ENG-CDR23021-R2-FDR-S1.pdf Markup Summary

Subject: SW - Textbox
Page Index: 1
Date: 4/2/2024 3:32:00 PM
Author: Glenn Reese - EPC Stormwater
Color: ■
Layer:
Space:
Page Label: 1

Subject:
Page Index: 4
Date: 4/9/2024 12:11:00 PM
Author: Jeff Rice - EPC Engineering Review
Color: ■
Layer:
Space:
Page Label: 4

DETENTION BASIN OUTLET STRUCTURE DESIGN

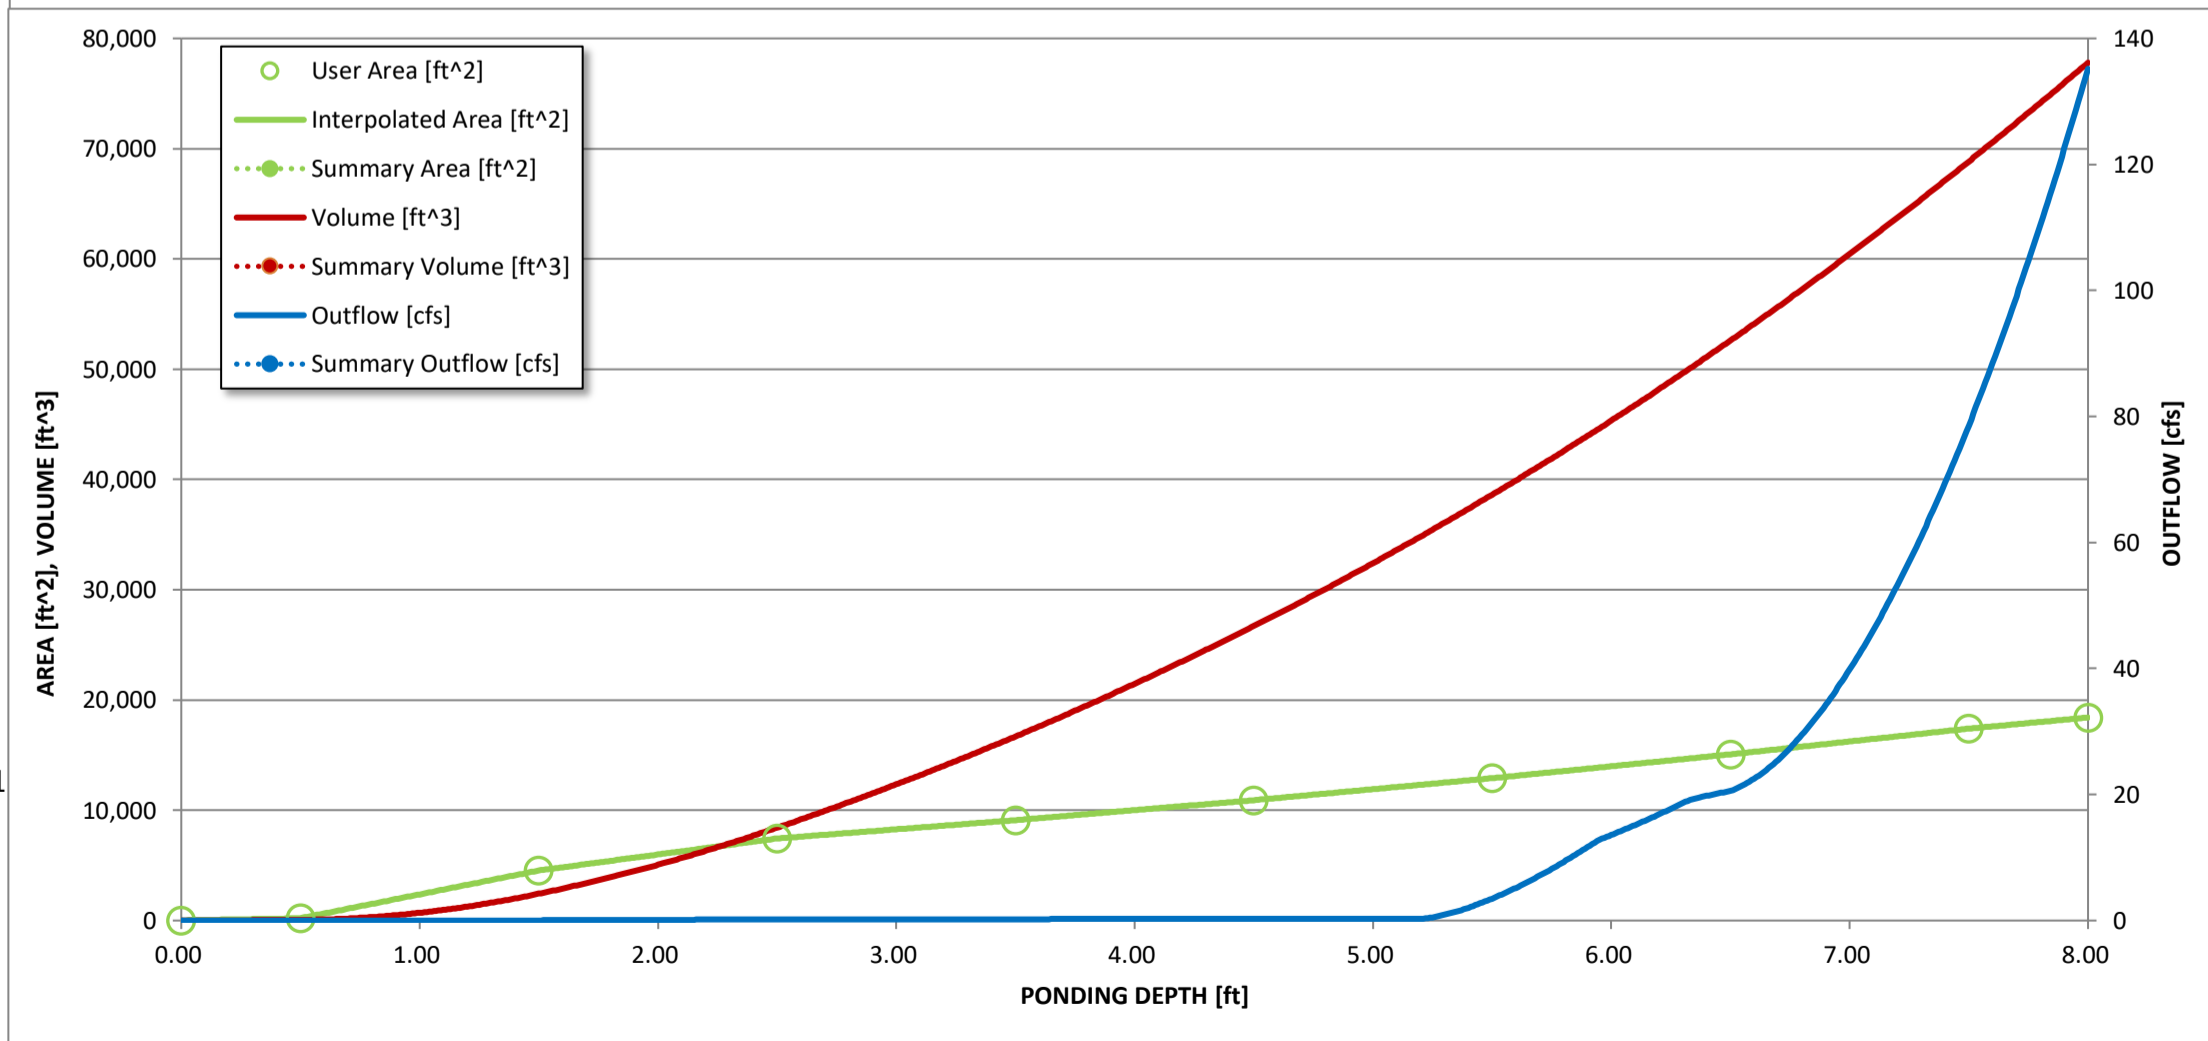
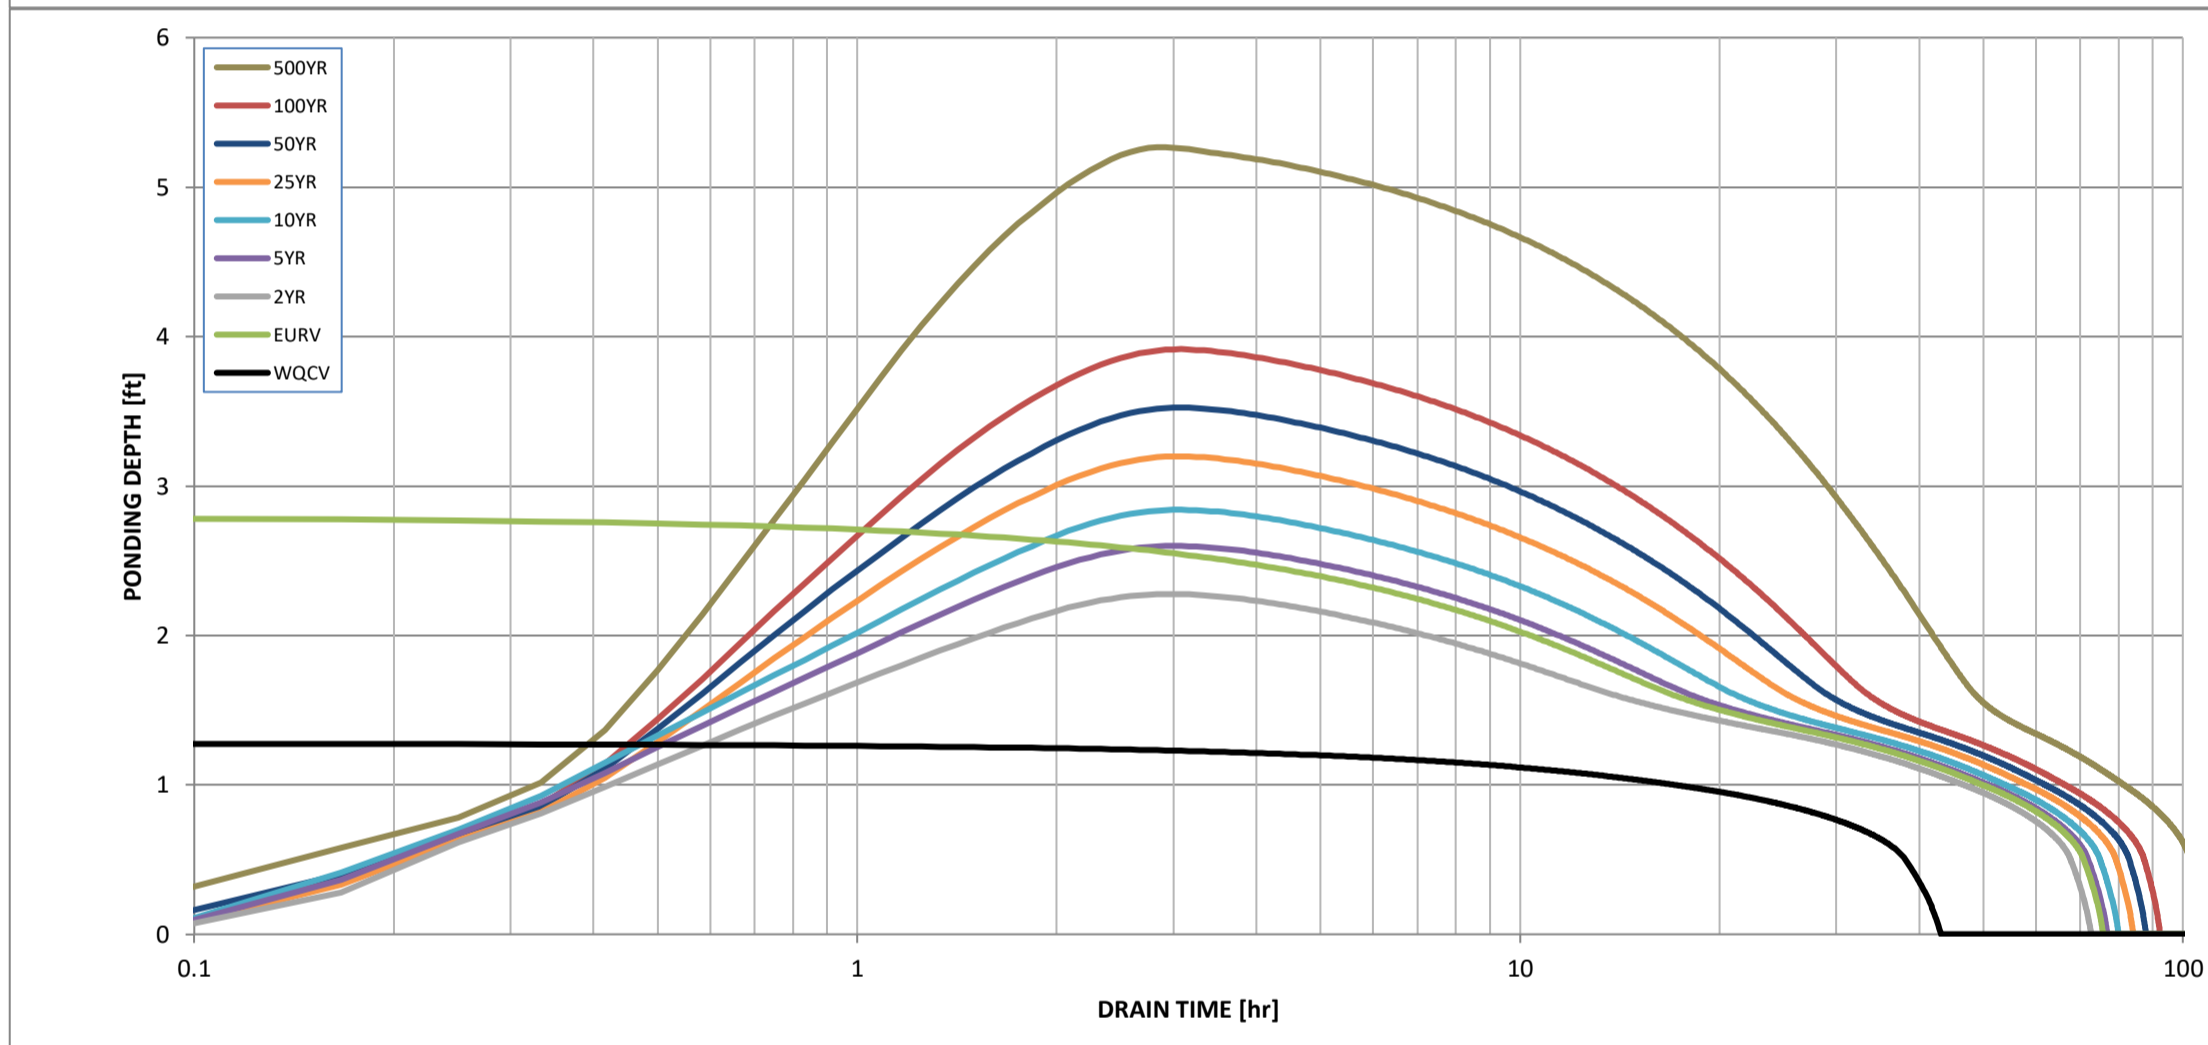
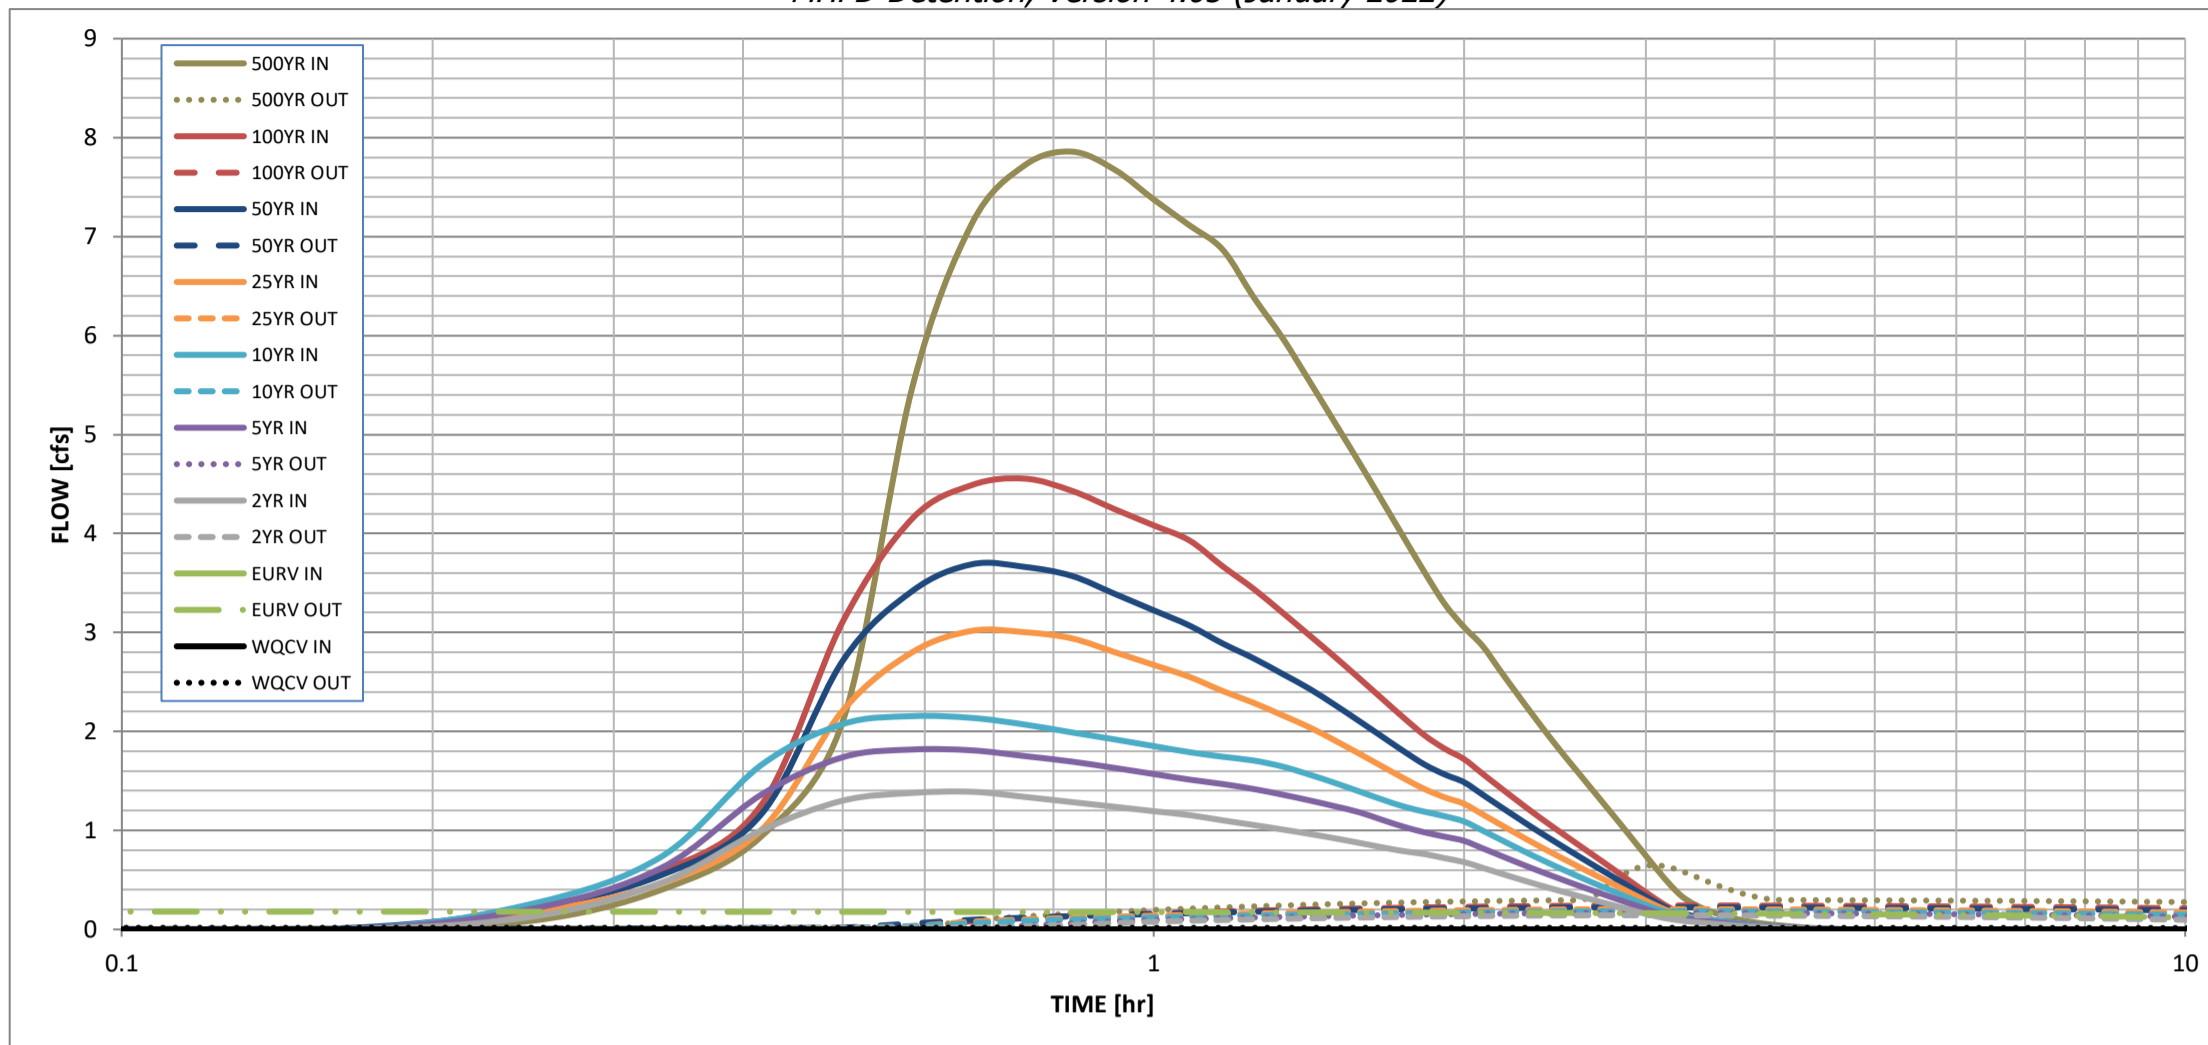
Why isn't this value that is >1 highlighted in red?
 Regardless, this ratio should be less than or equal to 1 for minor (5-yr) and major (100-yr) design storms. See Chapter 4.1 of DCM volume 2 (and also Chap 2 of MHFD DCM vol. 3).
